# ENG-SF21020-R1-GEC.pdf Markup Summary

Add text:  
PCD Filing No.:  
SF-21-020

EPC STORMWATER REVIEW COMMENTS  
IN BLUE BOXES WITH BLUE TEXT

EPC-ENGINEERING REVIEW COMMENTS  
IN BLUE BOXES WITH BLUE TEXT

**G4.1**  
Sheet 14 of 23

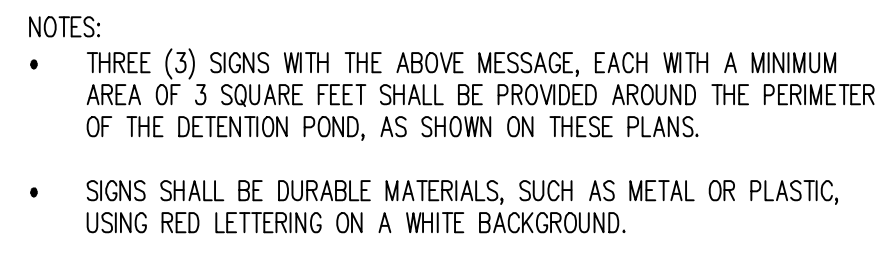
Revise to min 75ft length per my comment on sheet G6.5.

Checklist Item "r" - Slopes greater than 3:1 will need ECB or equivalent protection. Show/notate location of ECM on plans and Legend, as well as detail on final sheets.
